Ribble Valley Borough Council
Council Offices
Church Walk,
Clitheroe
Lancashire
BB7 2RA

Phone: 0300 123 6780
Email: developeras@lancashire.gov.uk
Your ref: 3/2025/0754
Our ref: 3/2025/0754/HDC/KW
Date: 07 January 2026

Location: Unit B Bee Mill Preston Road Ribchester Lancashire PR3 3XL
Proposal: Proposed change of use from Class E to Class B2 for peanut butter production.
Grid Ref: 364839 435365

Client	Freda's Peanut Butter
Job	Bee Mill, Ribchester
Title	Box Van - Swept Path Analysis

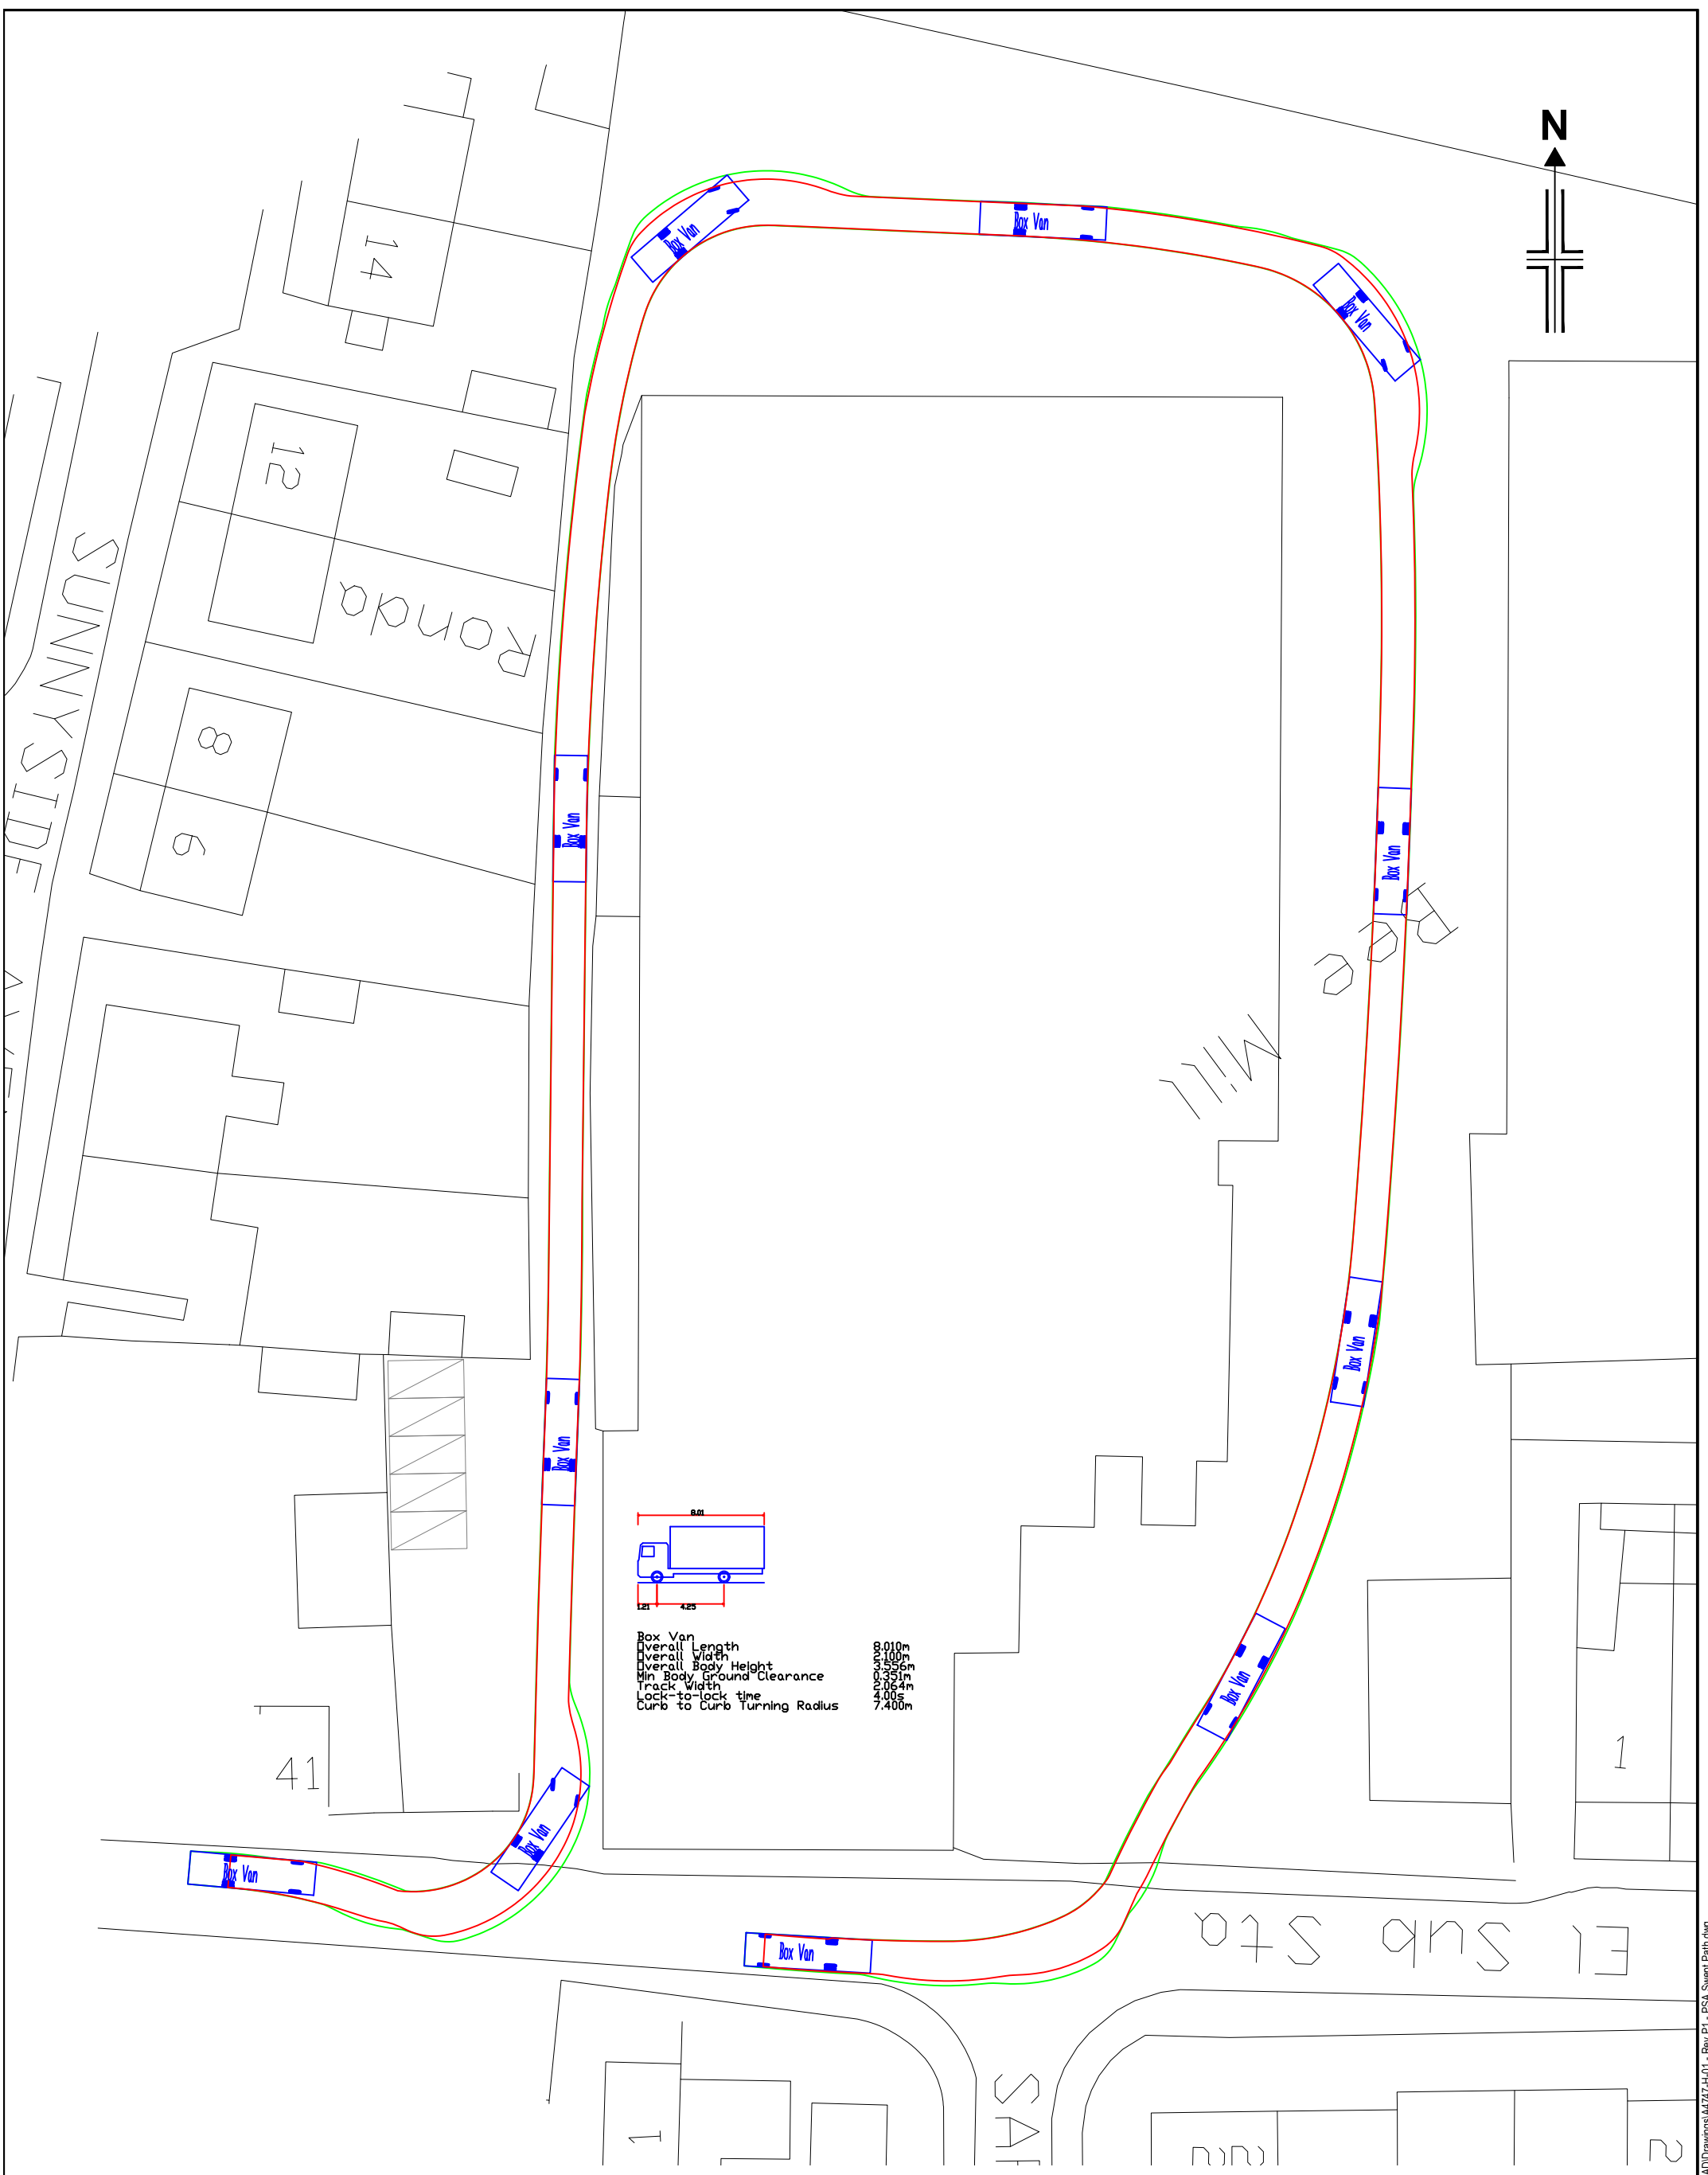
Vehicle tracking shows that the wider industrial estate operates a one-way system, with the largest vehicle serving the site being able to manoeuvre into the site and out of the site safely in a forward gear.

1. The site shall operate in accordance with the approved operating statement titled Technical Note 1 dated 15th December 2025. The business operations within the site shall not be amended unless first approved in writing by the Local Planning Authority in consultation with the Highway Authority.
